From: Robert Harbour [REDACTED]
Sent: 22 October 2015 11:35
To: David Easton
Subject: Re: R/221/15/HH - 5 Hawke Close, Rustington

I attach amended plans HC/4a HC/11a HC/12a & HC 13a with reference to R/221/15/HH indicating roof windows in place of the dormer windows originally shown on the primary front elevation as discussed.

DRG. NO HC/11

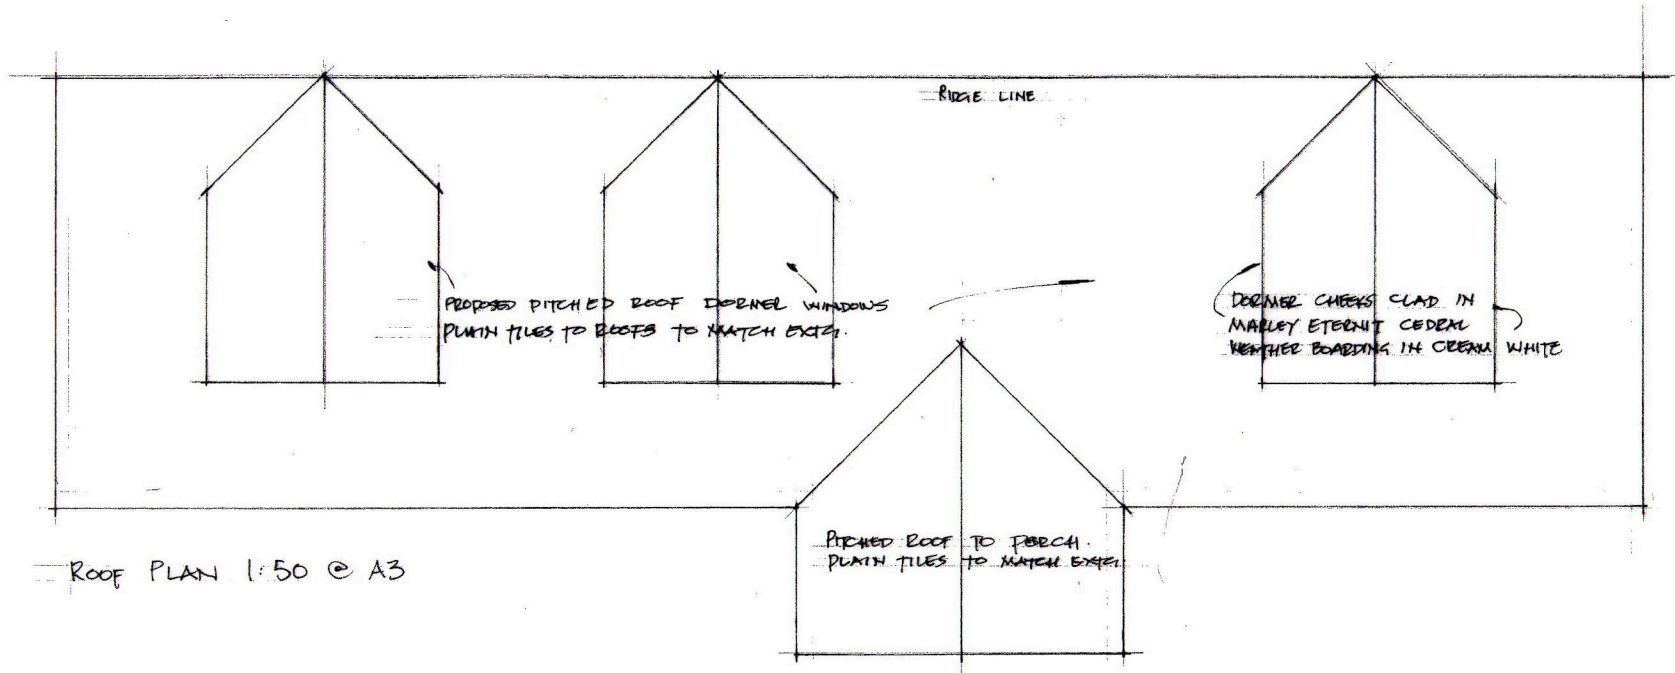
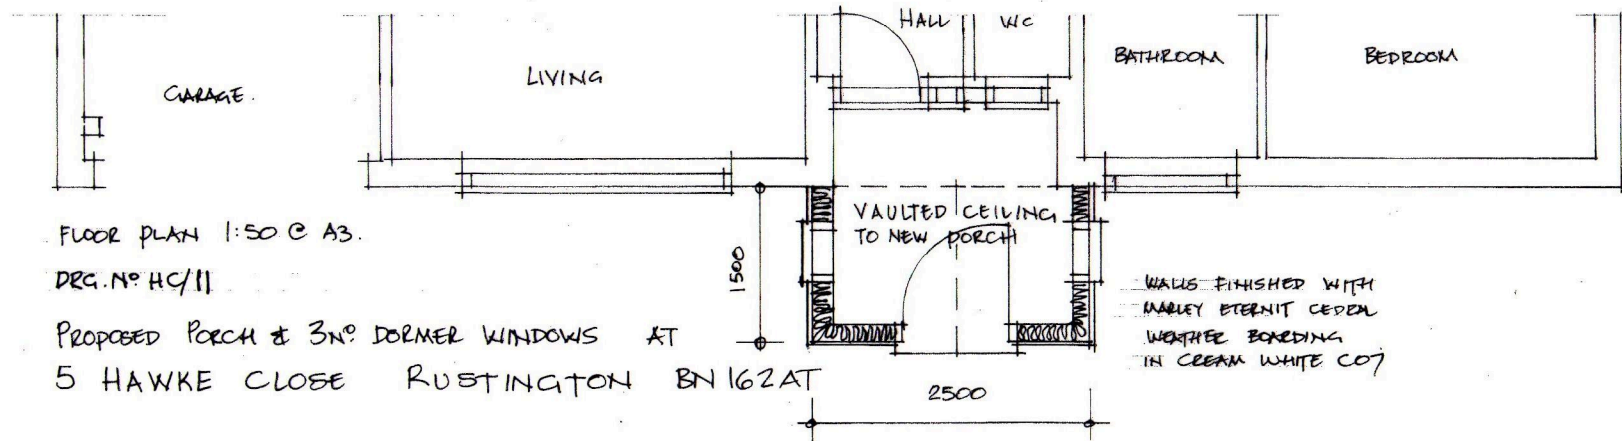
Following our telephone and further discussions with my team leader in relation to this application, I can confirm that the dormers are not considered to appear subservient or be in keeping with the existing character of the area.

DRG. NO. HC/12

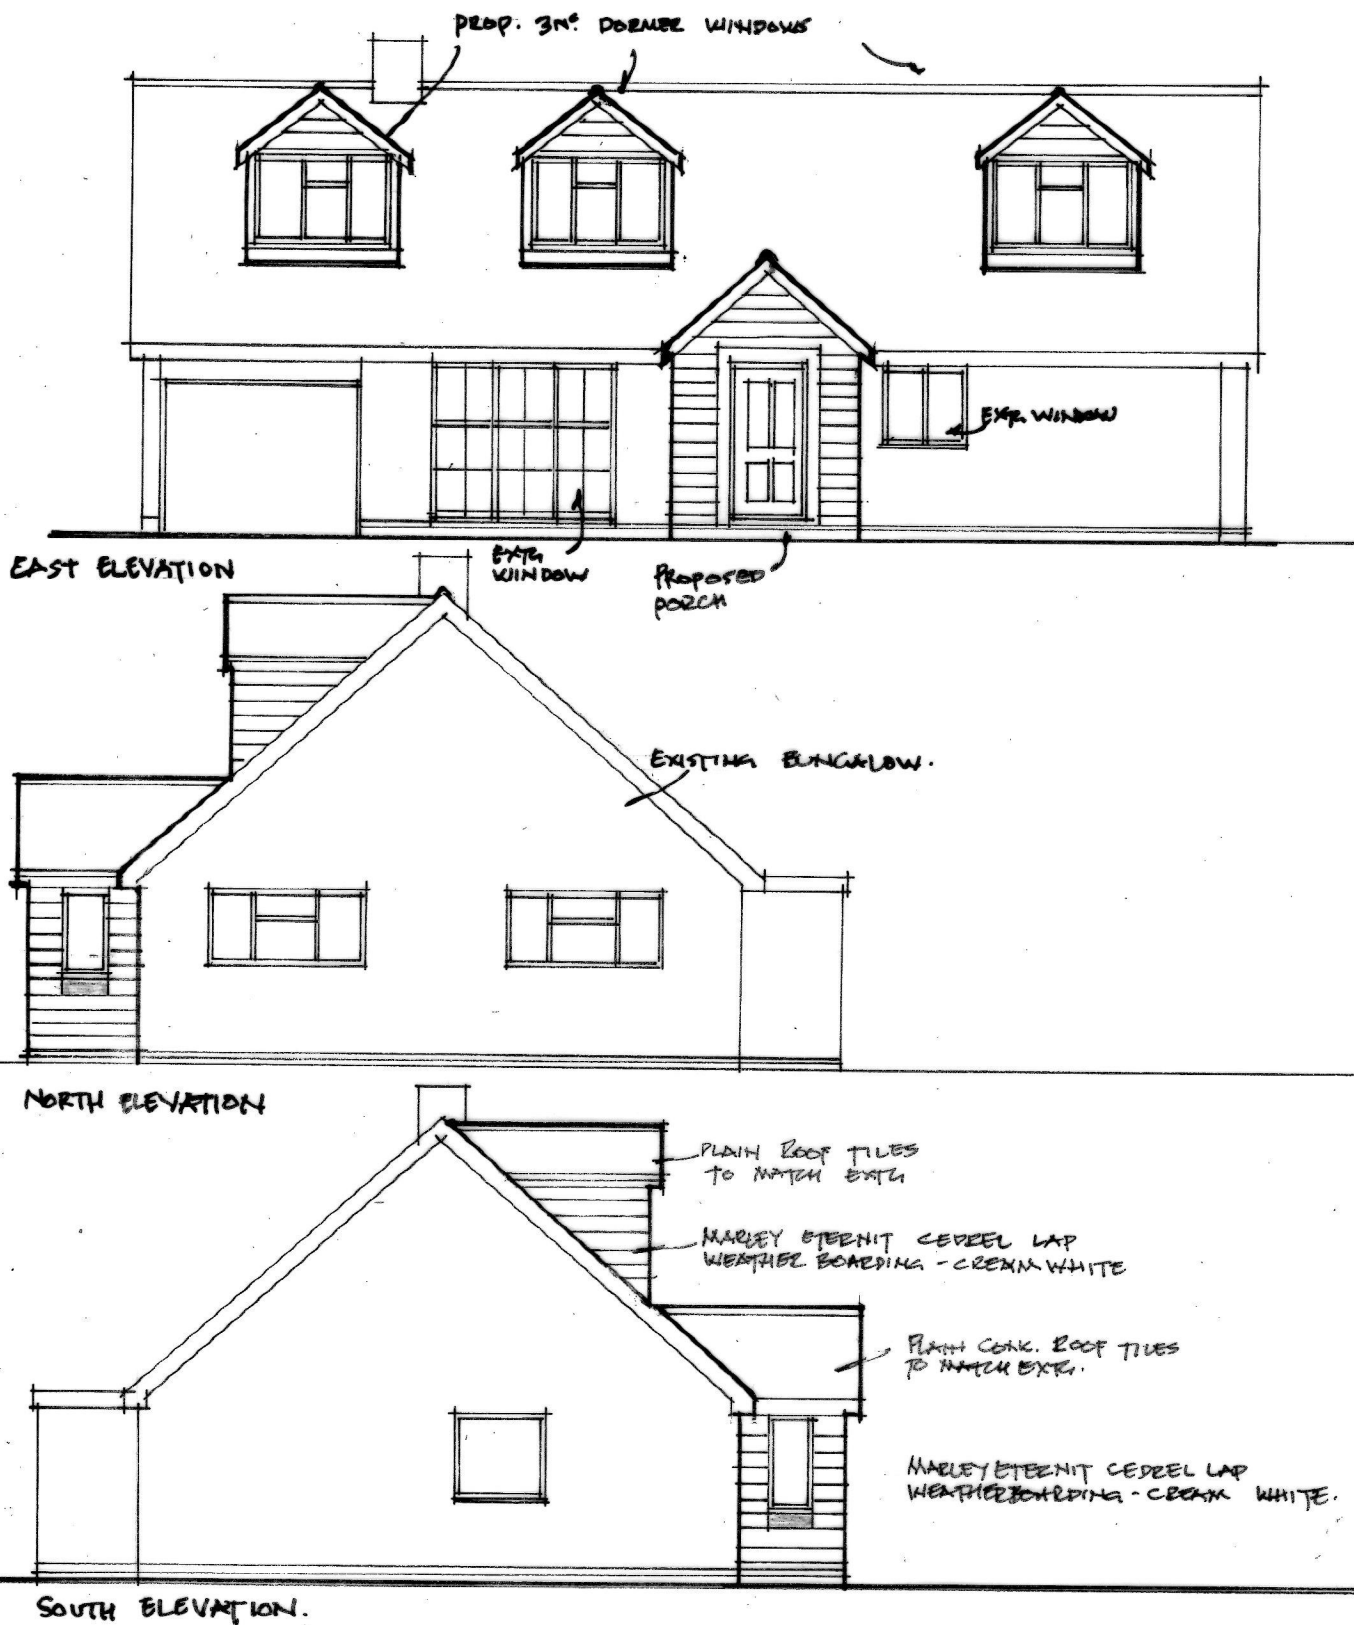
In relation to the porch I can confirm that we are both happy with the design and consider it to be subservient to the host dwelling and does not have an unacceptable impact upon the character or appearance of the area. However, some concerns were raised in relation to the proposed use of weatherboarding which is an alien material in this location. Therefore, I would advise that were you to submit a revised scheme that it should include the removal of the dormers from the primary elevation and the use of materials which match those of the existing dwelling.
